From: Anita Gardner
Sent: 07 December 2017 18:06
To: Karen Parsons
Subject: FW: Beechlands Close EP/138/17

Subject: Beechlands Close EP/138/17

Proposed Site Plan, Block Plan
and Location Plan

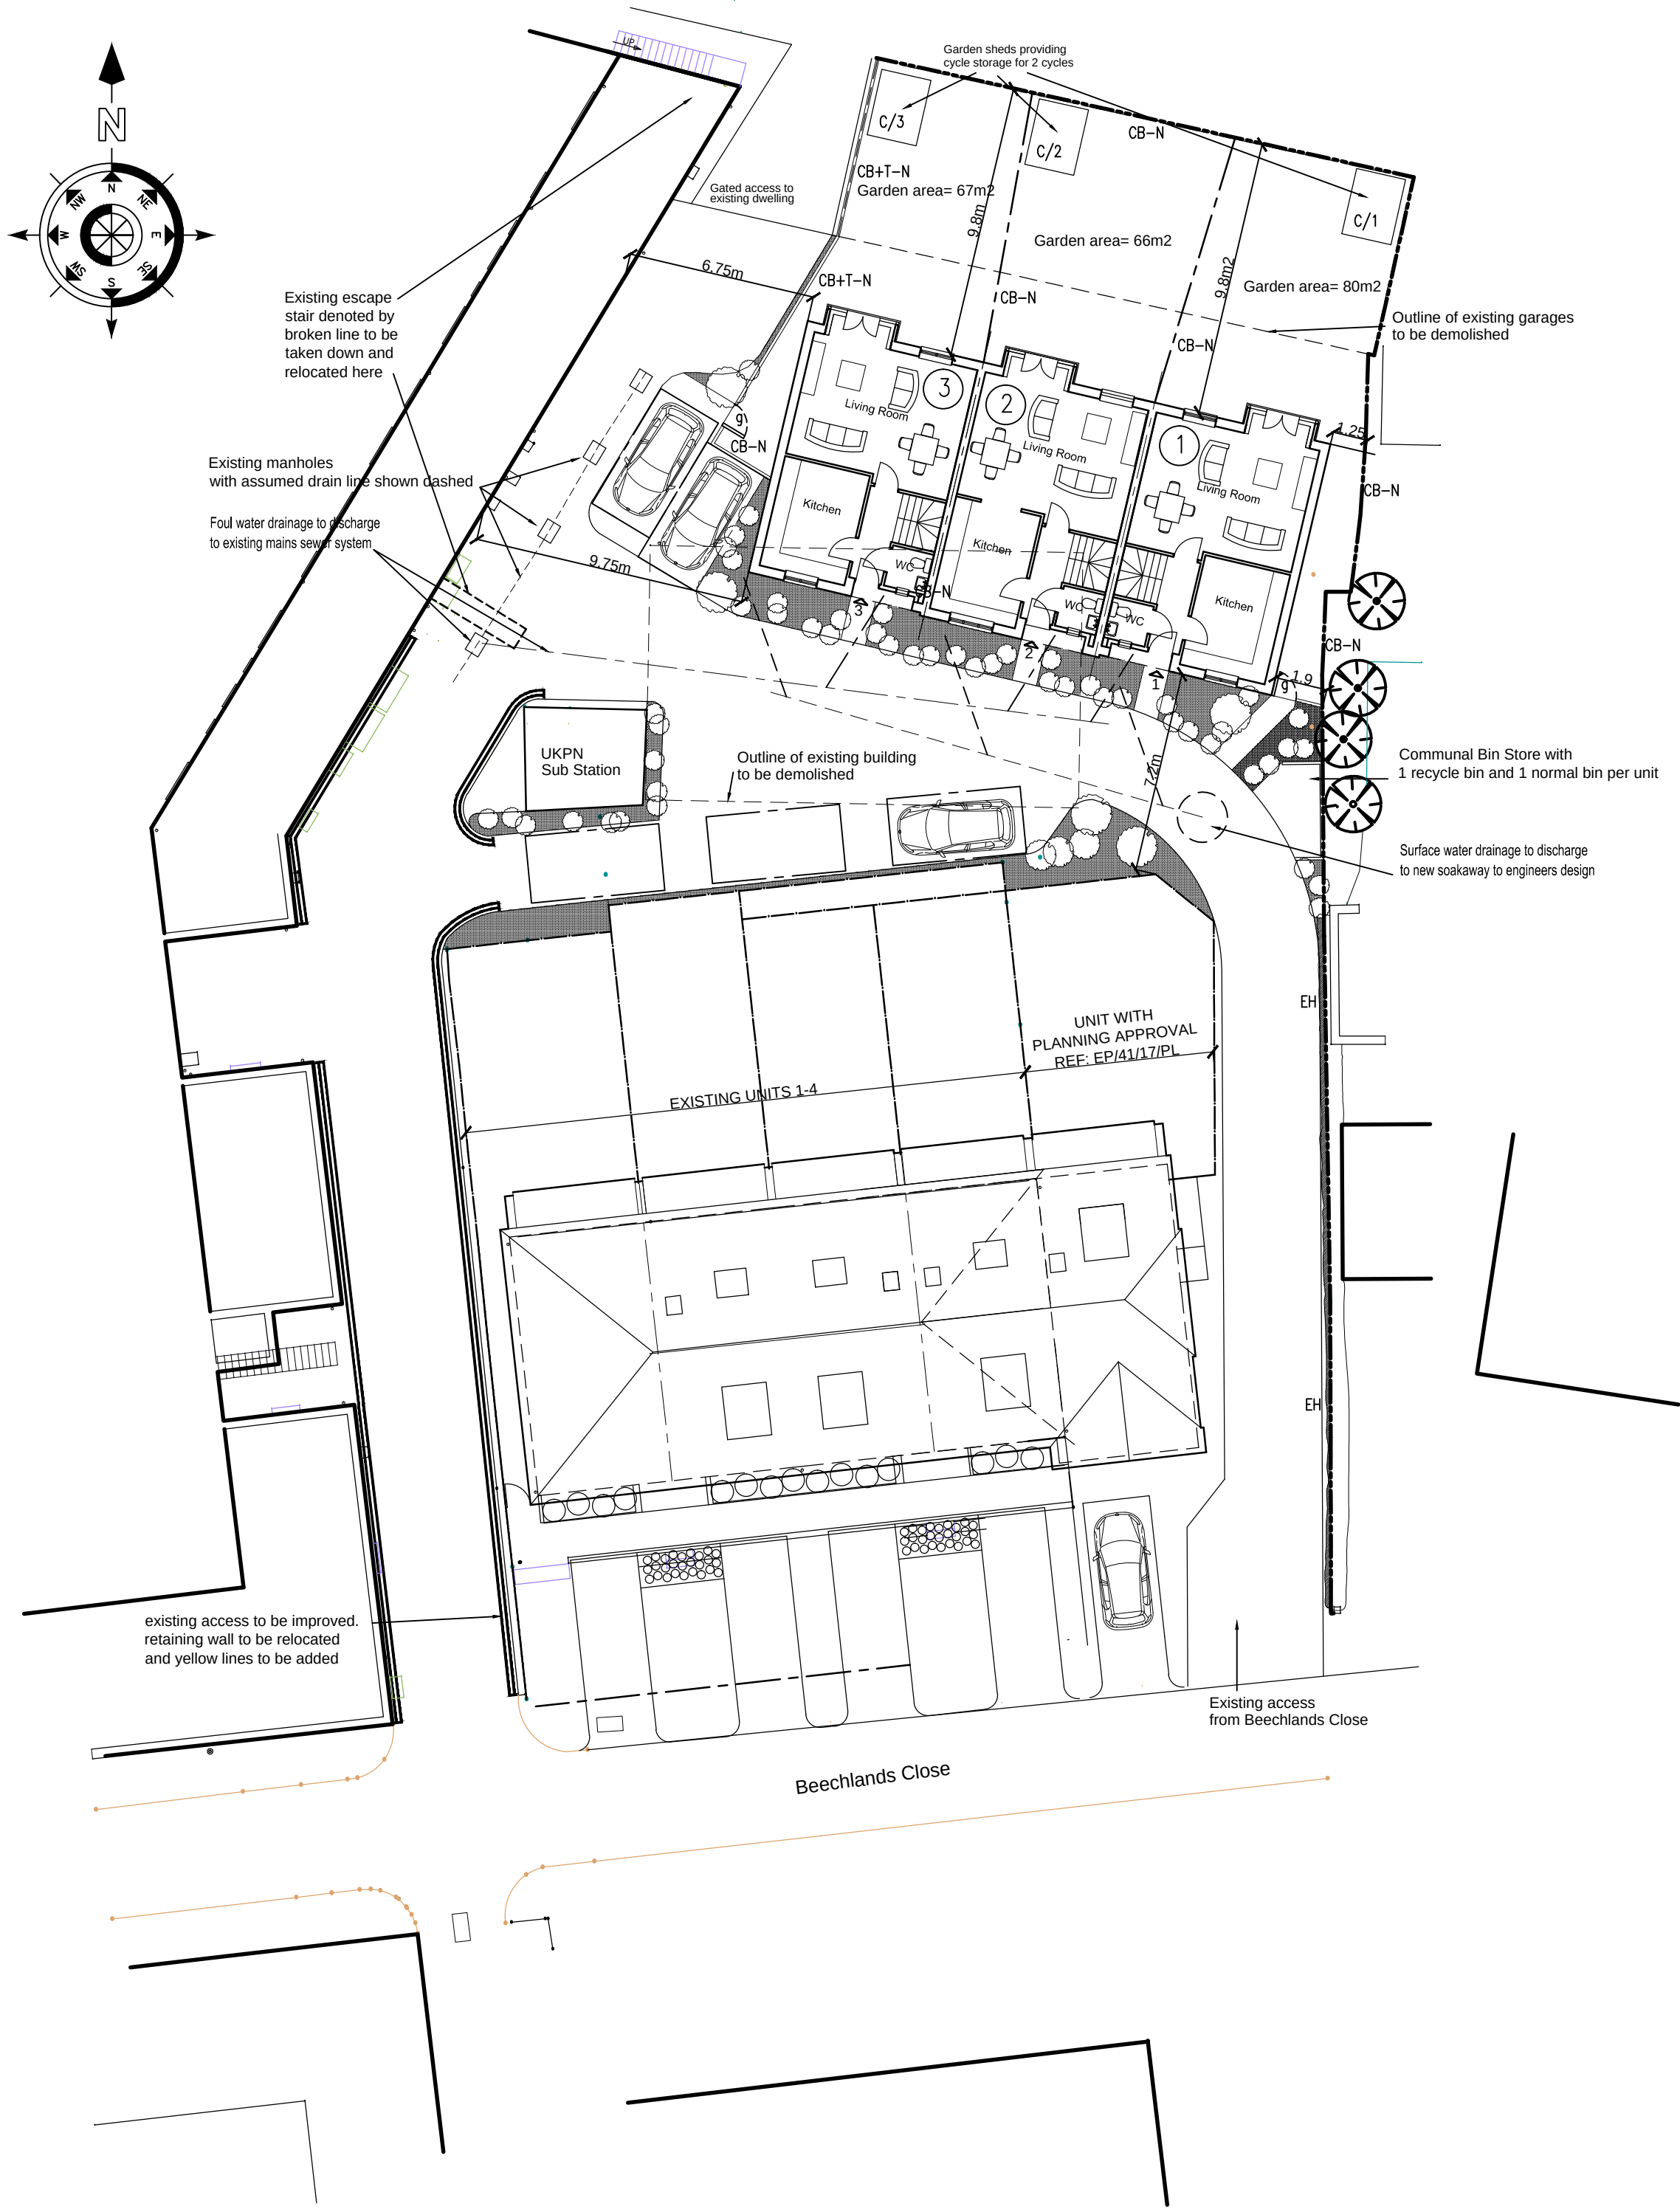
I acknowledge receipt of the revised site plan and your response letter. I will need to re-consult with County Highways given the provision of the bin and trolley storage for the shops and the amended parking place position. I also note that the position of the existing fire escape stairs differs on the existing and proposed site plans. It is indicated in a more northerly position on the existing site plan. Please can you amend the plans so that both are correct.

Thank you for your email and I will get the position of the fire escape checked and amended.
